**WELWYN HATFIELD BOROUGH COUNCIL – DEVELOPMENT MANAGEMENT**  
**DELEGATED REPORT**

<b>APPLICATION No:</b>	<b>S6/2012/1258/FP</b>
<b>APPLICATION SITE:</b>	<b>Wildwood, Kentish Lane</b>

This application seeks full planning permission for the erection of a swimming pool enclosure. The footprint of the new building would measure approximately 17.6m x 10.3m (181sqm measured externally) and would adjoin an existing outbuilding which houses a changing room and shower. The swimming pool enclosure would feature a flat roof concealed behind a parapet wall measuring approximately 3.6m in height. Externally the enclosure would be finished in white render with stone cladding detail to match the main house.

second floor plan

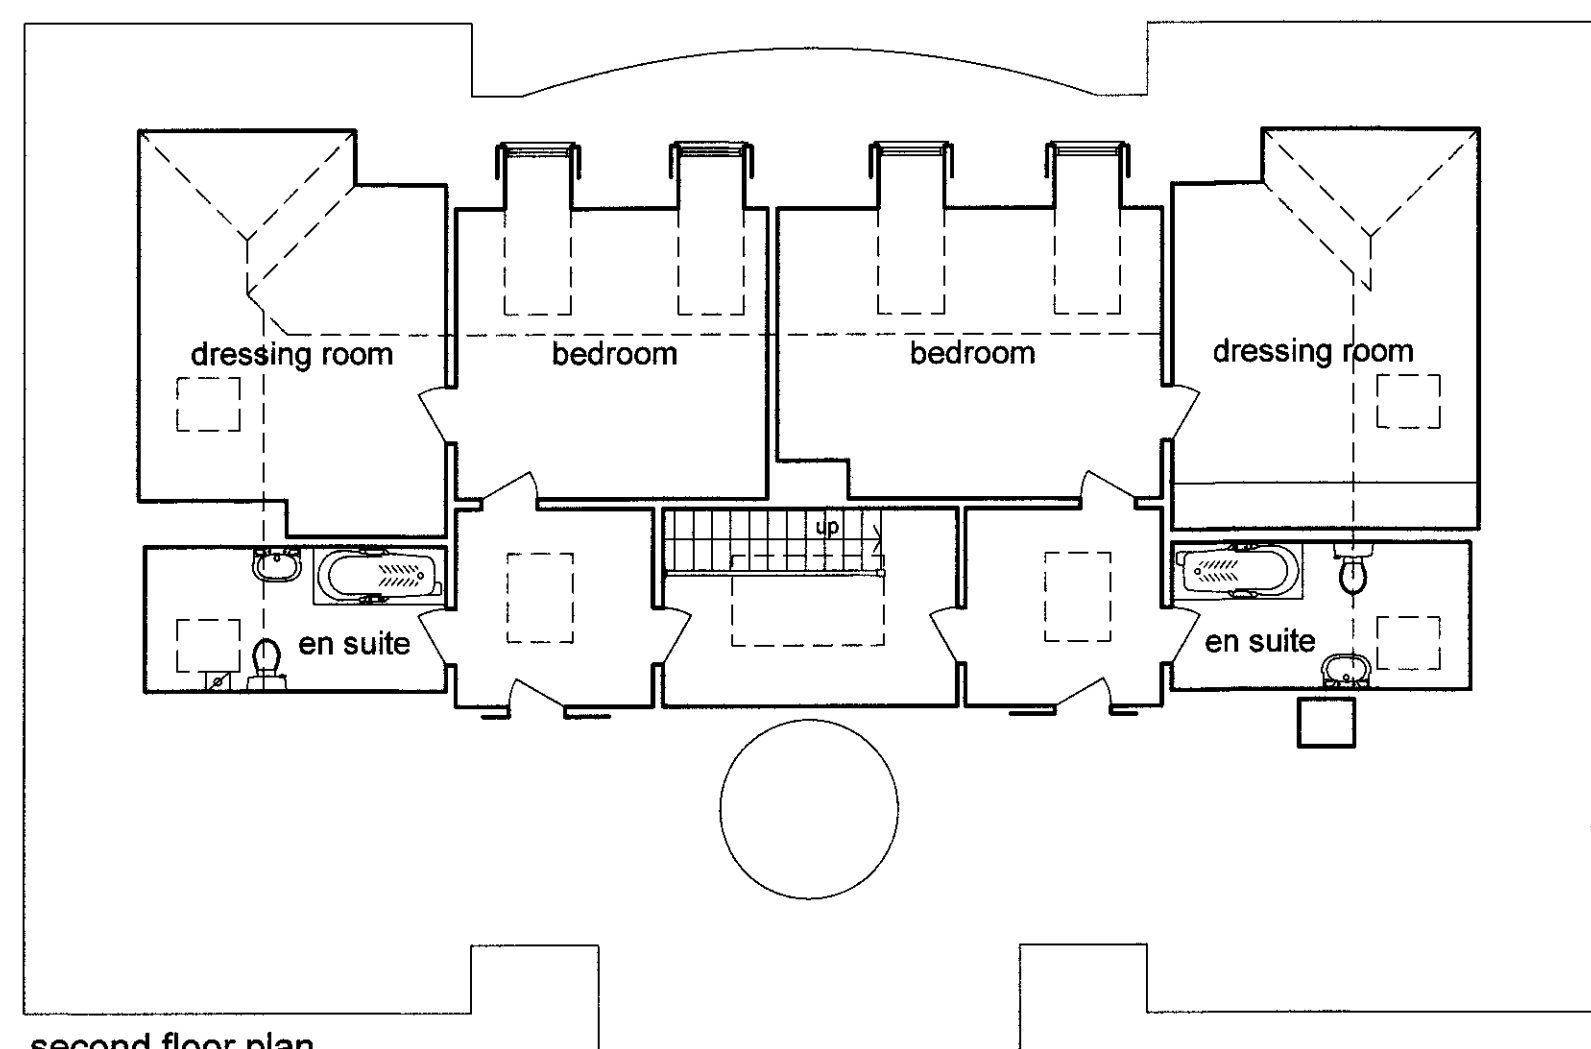
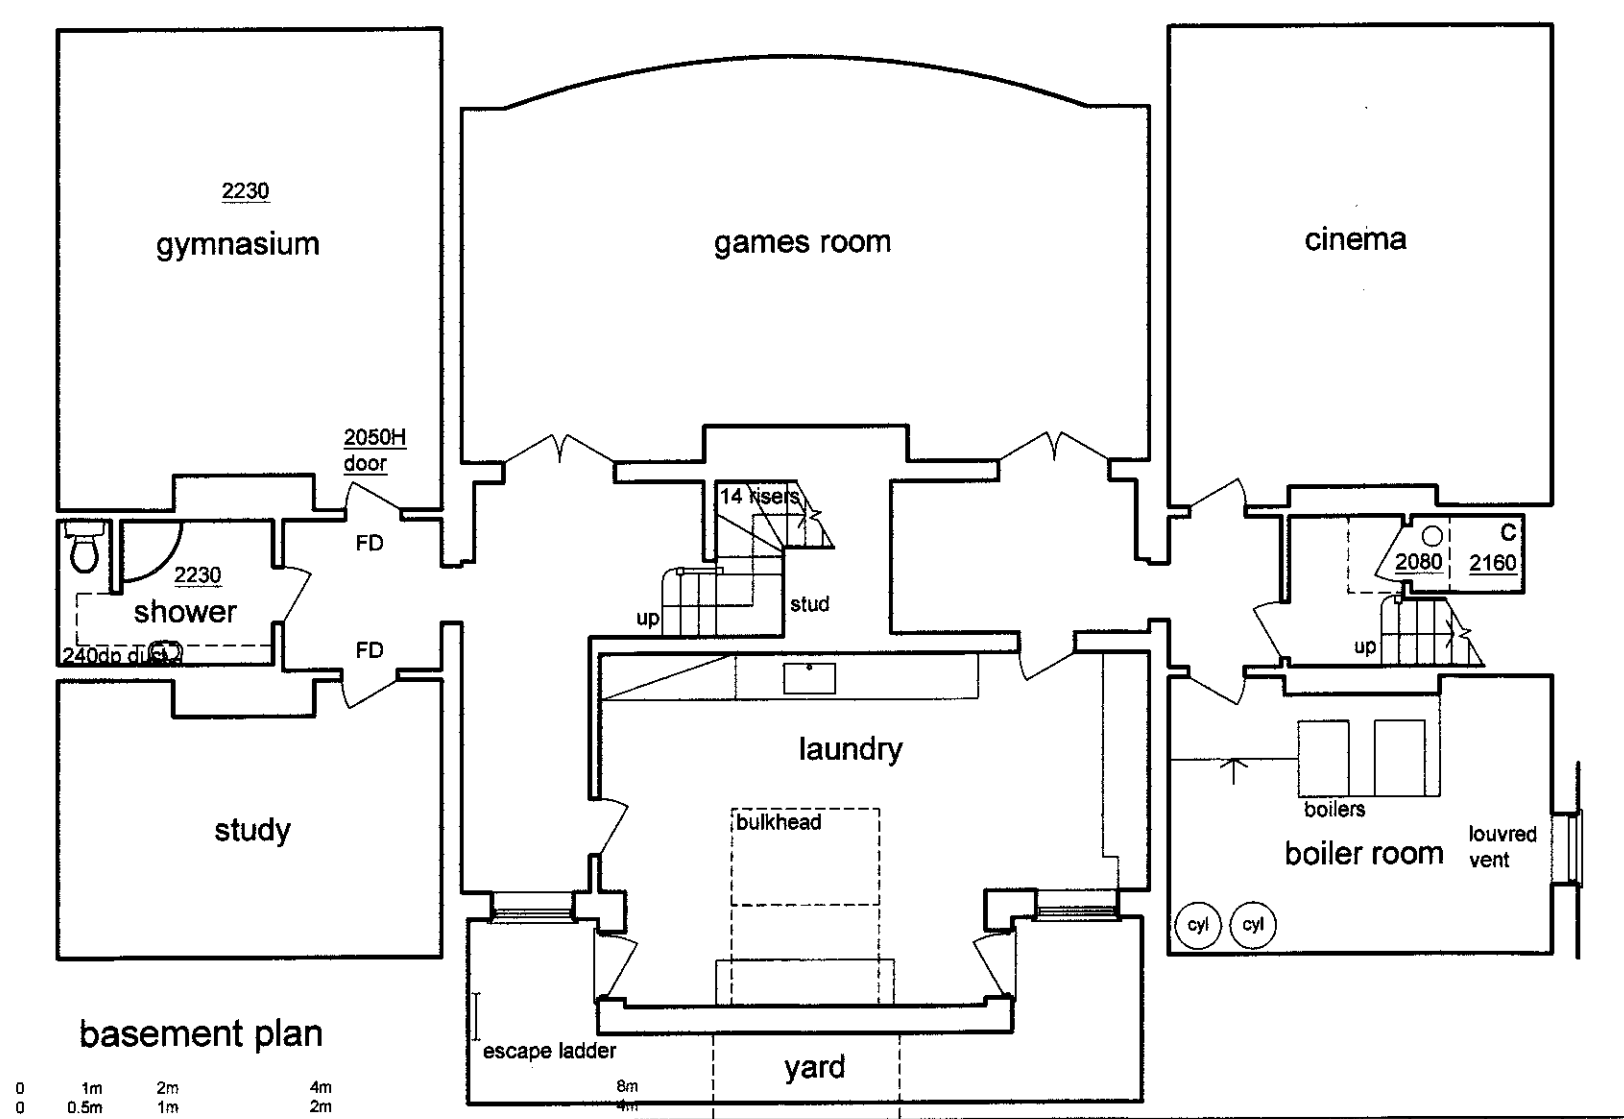
At the time of the site visit an orangery extension was under construction to the north east side of the application dwelling (planning reference S6/2011/0208/FP granted on appeal). Prior this, the dwelling itself has not been extended since it was built as a replacement dwelling. Although the dwelling had not previously been extended, it is relevant that the roof space has been converted to provide additional habitable

accommodation as shown on drawing 10424-s003-A. Whilst it is acknowledged that planning permission S6/1052/97/FP included the introduction of “attic dormers”, these were intended to provide natural light to the attic which was not included in the calculation of habitable floor area when granting permission for the replacement dwelling (the Officer’s report and application form for planning permission S6/1052/97/FP are available on file).

10424-A1-PL07

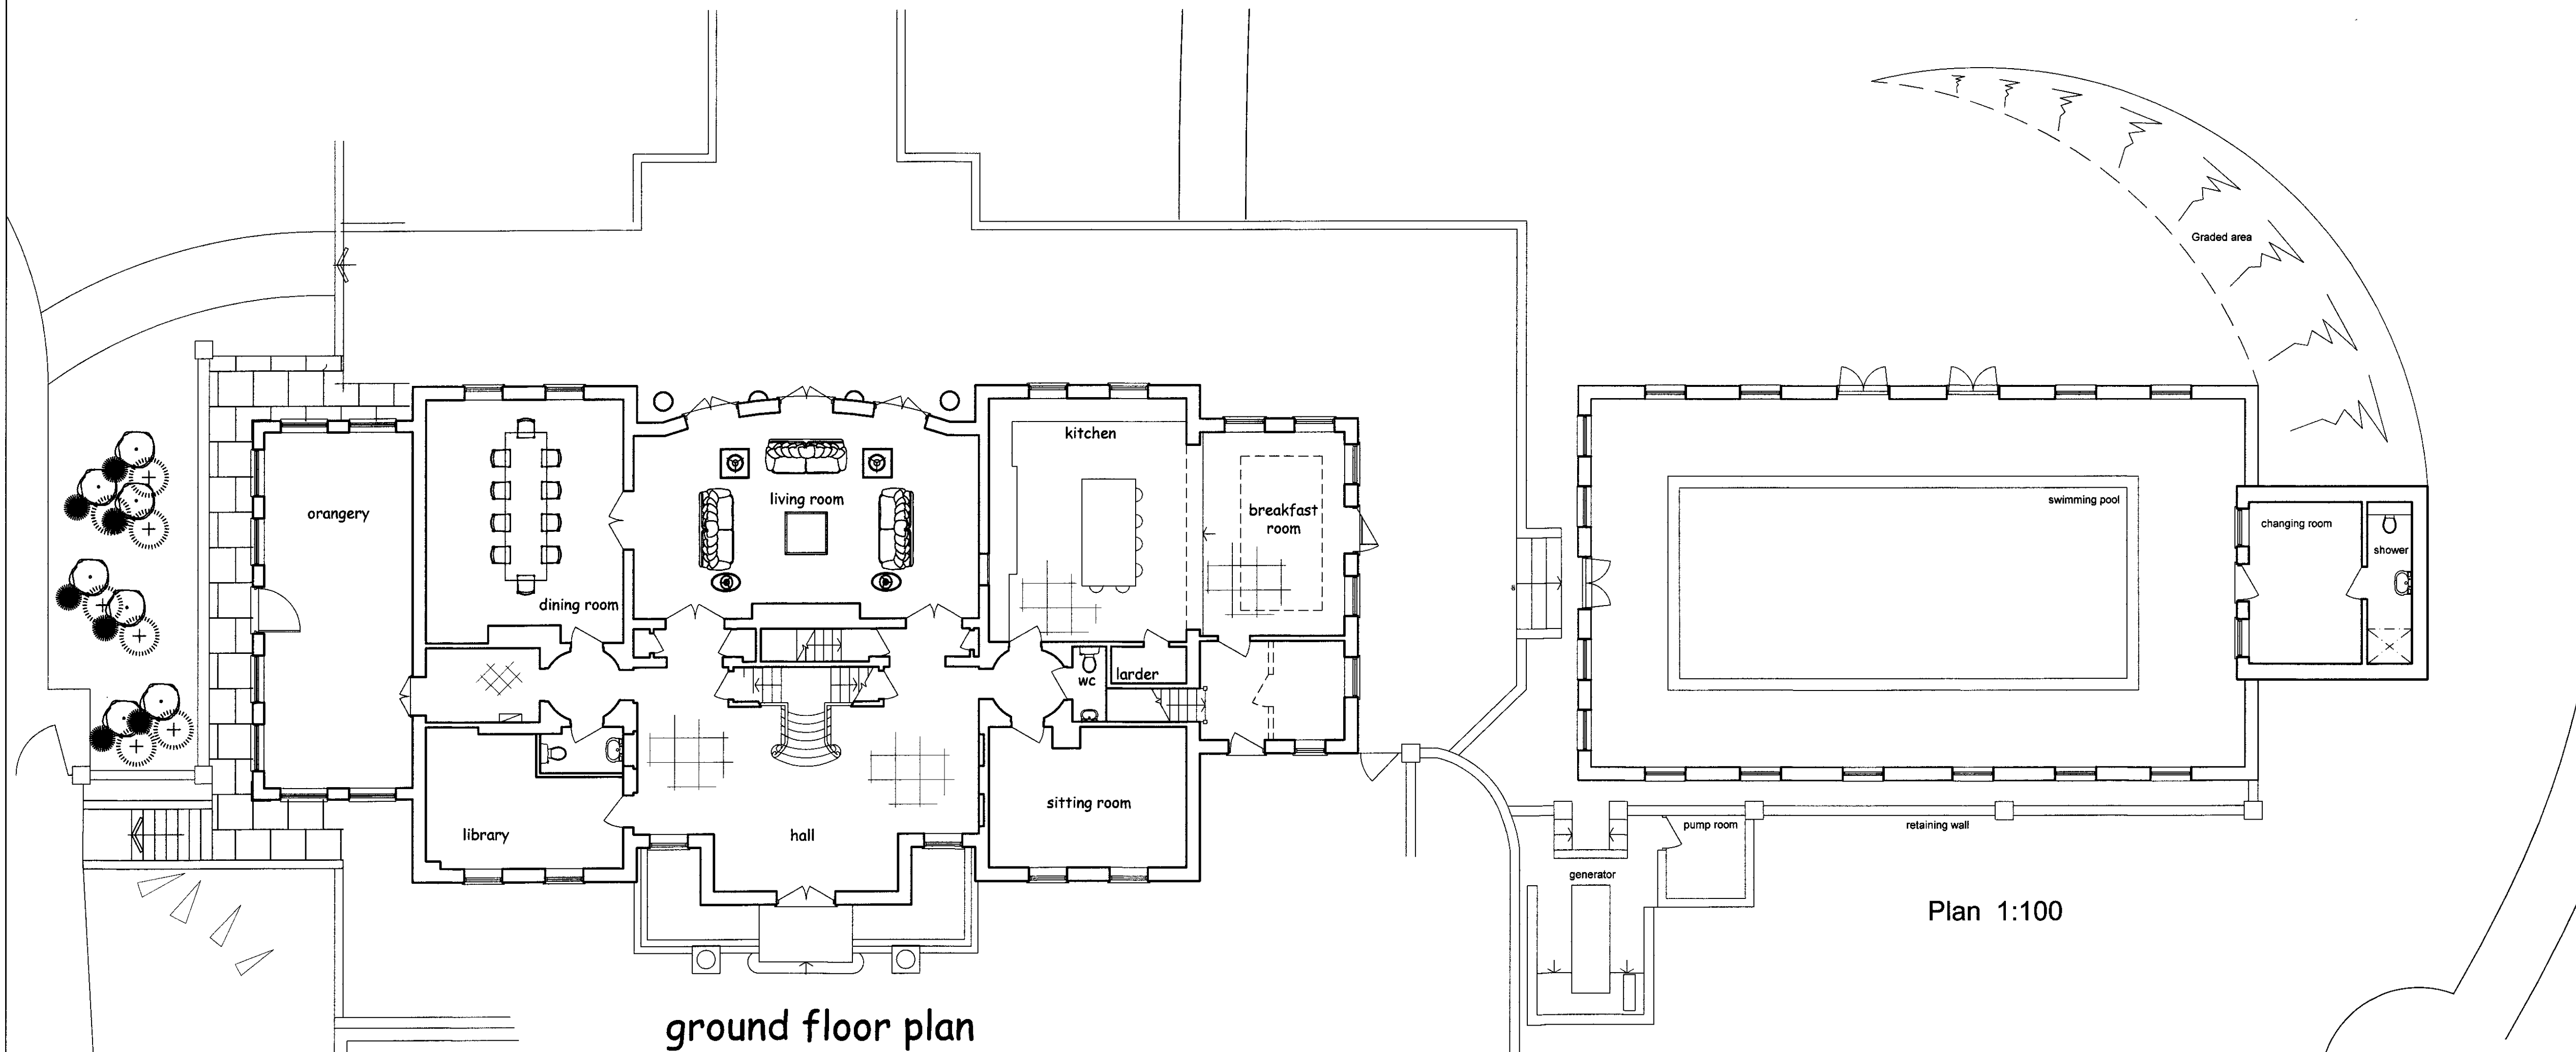
The applicant has reduced the size of the proposed building both in terms of its footprint and its height. The link to the main dwelling has also been removed creating approximately 5.7m separation distance between the main dwelling and the proposed swimming pool enclosure. It is agreed that the proposal would be subordinate to the

dwelling, however, it remains a very large structure with three dimensional bulk. To the substantial harm by reason of inappropriateness must be added the inevitable loss of Green Belt openness locally that addition of the proposed building would occasion. It is accepted that because the addition would be concealed from view from the highway and the surrounding countryside by trees, boundary fences and landform, the loss might not be readily apparent but it would none the less be tangible. Taking account of the aim of the NPPF to protect Green Belts from development it is considered that the presence of a building of this size would detract from the openness of the Green Belt and thereby conflict with one of its essential characteristics.

The increase in size of the application dwelling resulting from the proposed swimming pool enclosure is considered disproportionate over and above the size of the original building and therefore inappropriate development within the Green Belt contrary to the first criterion of Policy RA3 of the Welwyn Hatfield District Plan 2005 and the National Planning Policy Framework. The increased bulk and massing would result

in a reduction in the openness of the immediate surroundings contrary to the second criterion of Policy RA3 of the Welwyn Hatfield District Plan 2005 and the National Planning Policy Framework.
